Planning Application Reference No.: 3/2025/0363

Address of Development: Land off Pendle Street East Sabden BB7 9EQ

With regards to the above planning application (3/2025/0363), I wish to raise my objection based on the following points:

ELEVATION

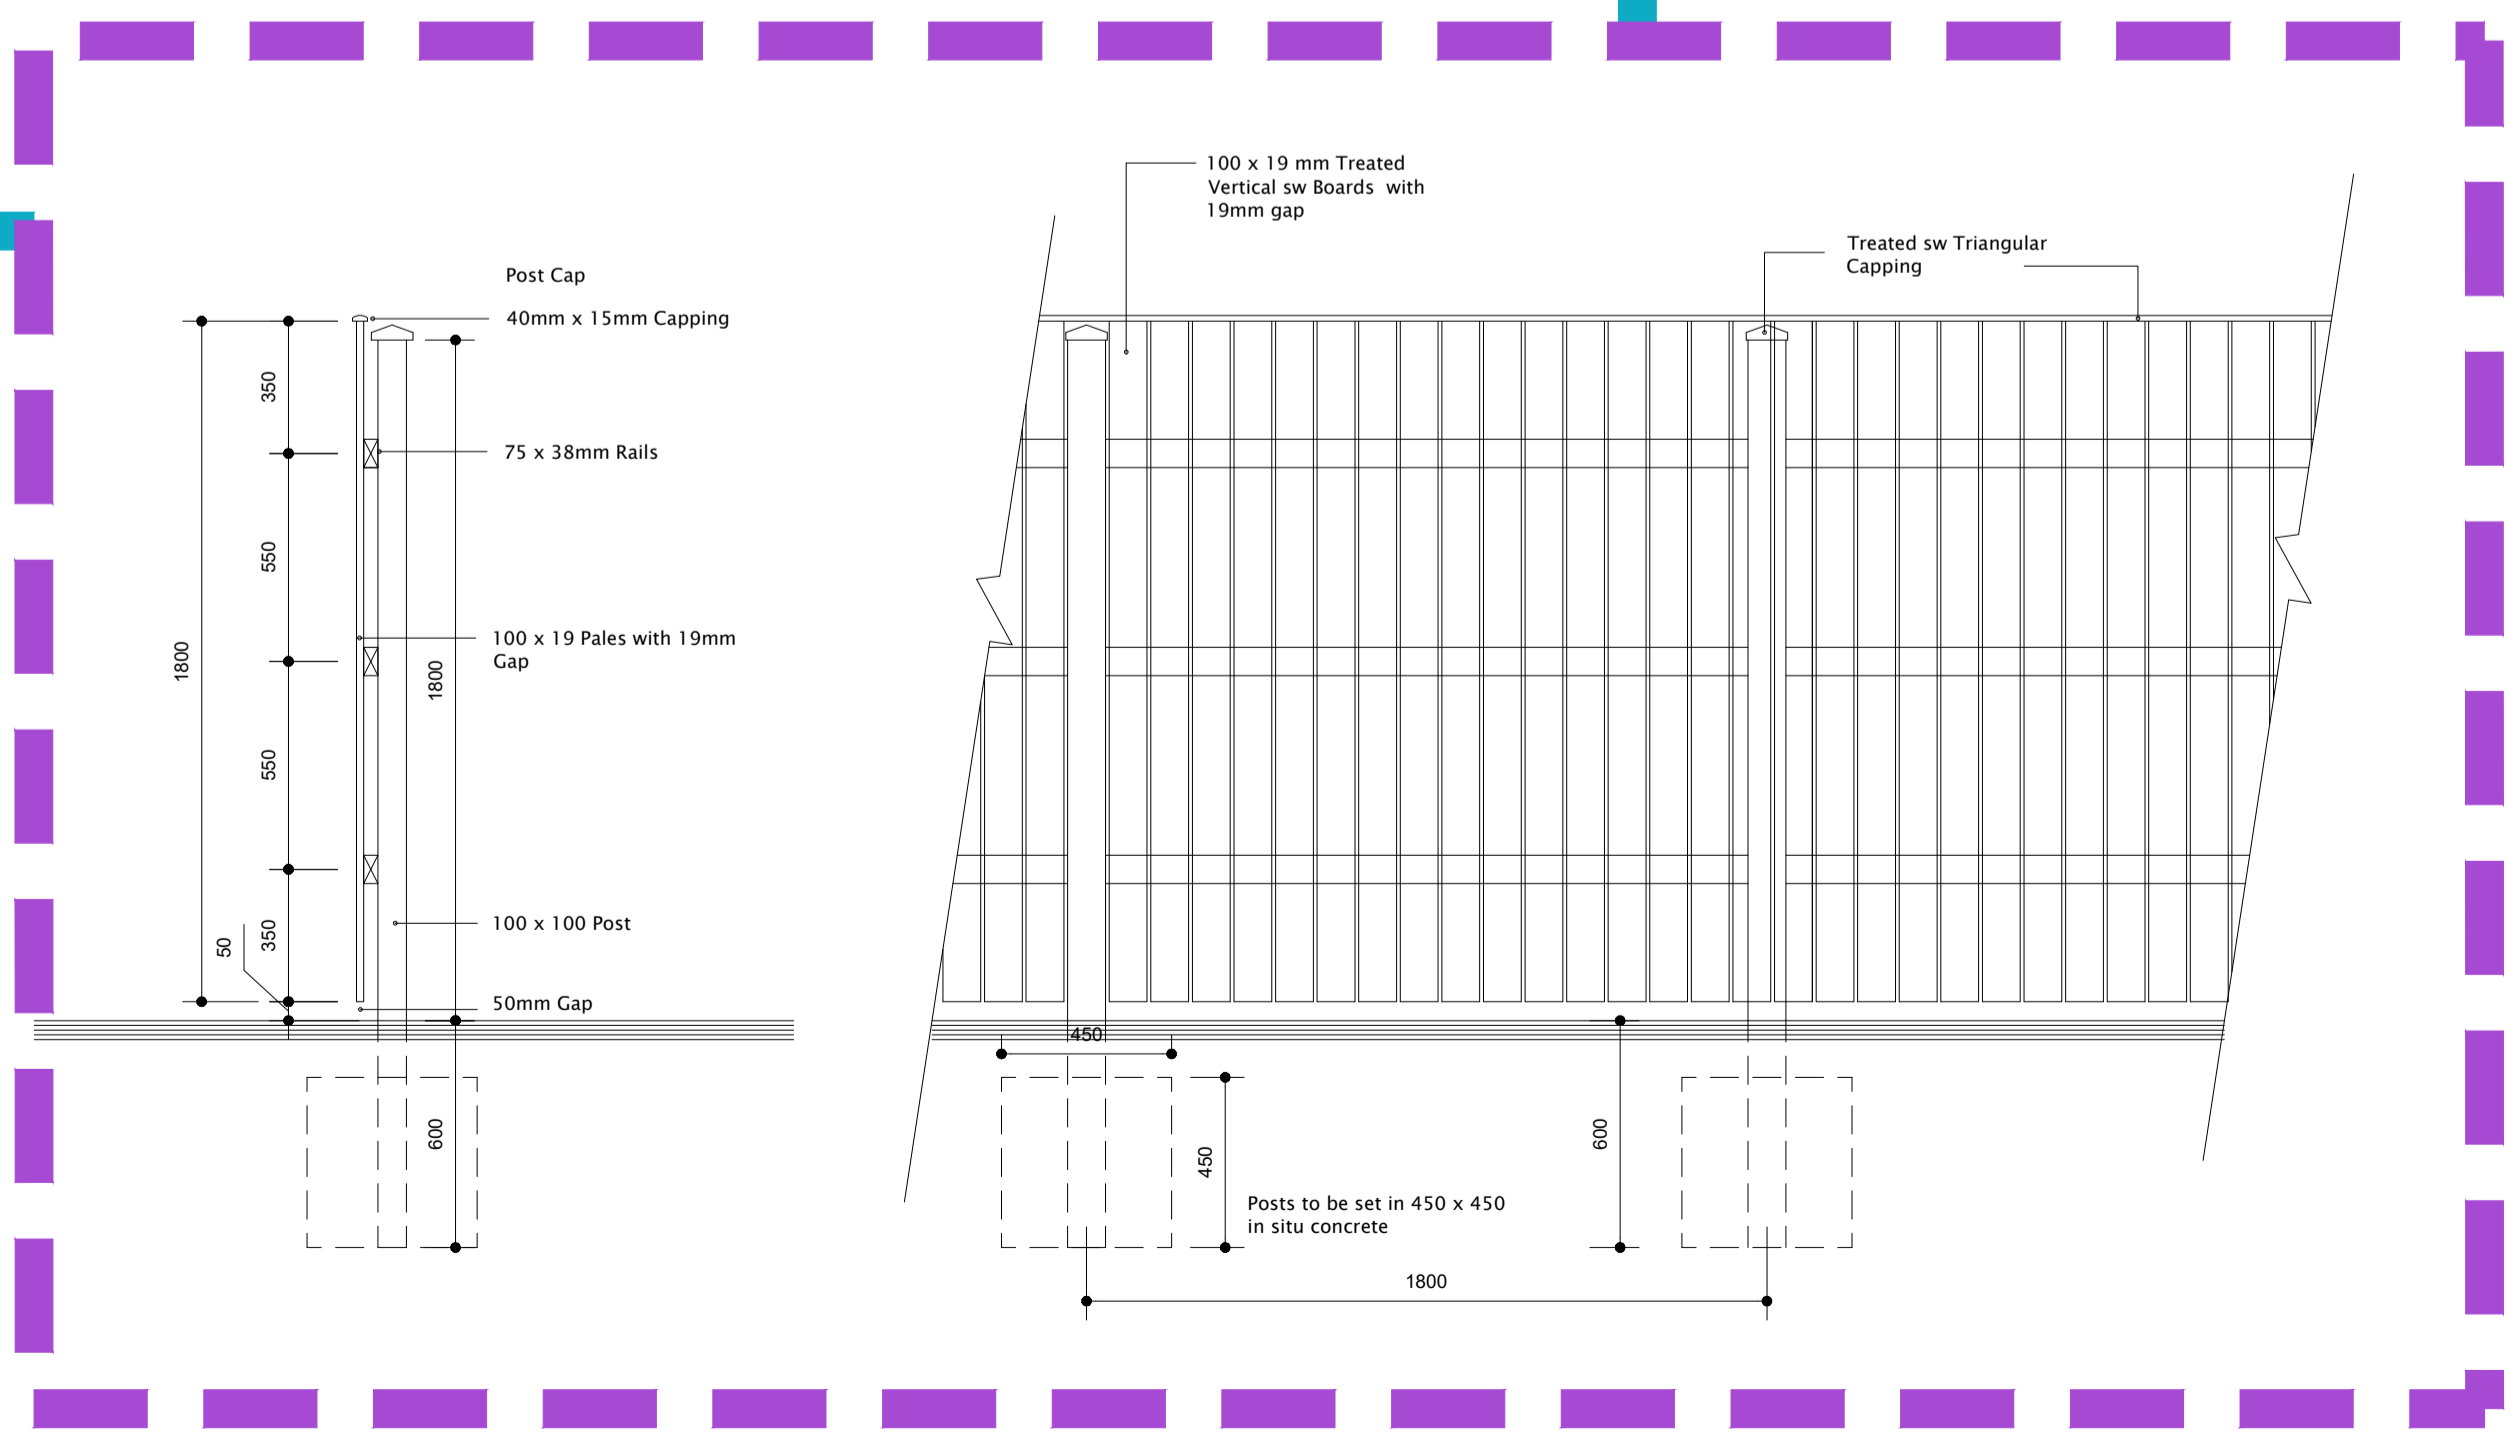
6. The suggested boundary walling in artificial stone is completely wrong for this setting. Walling of this type is not seen anywhere in the village to my knowledge and is both out of place and out of character for this small rural location. Even the nearby mediocre Cobden Close development uses real stone boundary walls. Such poorly considered boundary walling will jar, separate, and segregate the occupants of the proposed development rather than integrating them into a close-knit village community. The developers should look at the recent Skipton Properties/Victoria Mill development to see how to successfully integrate a new development into a rural village.
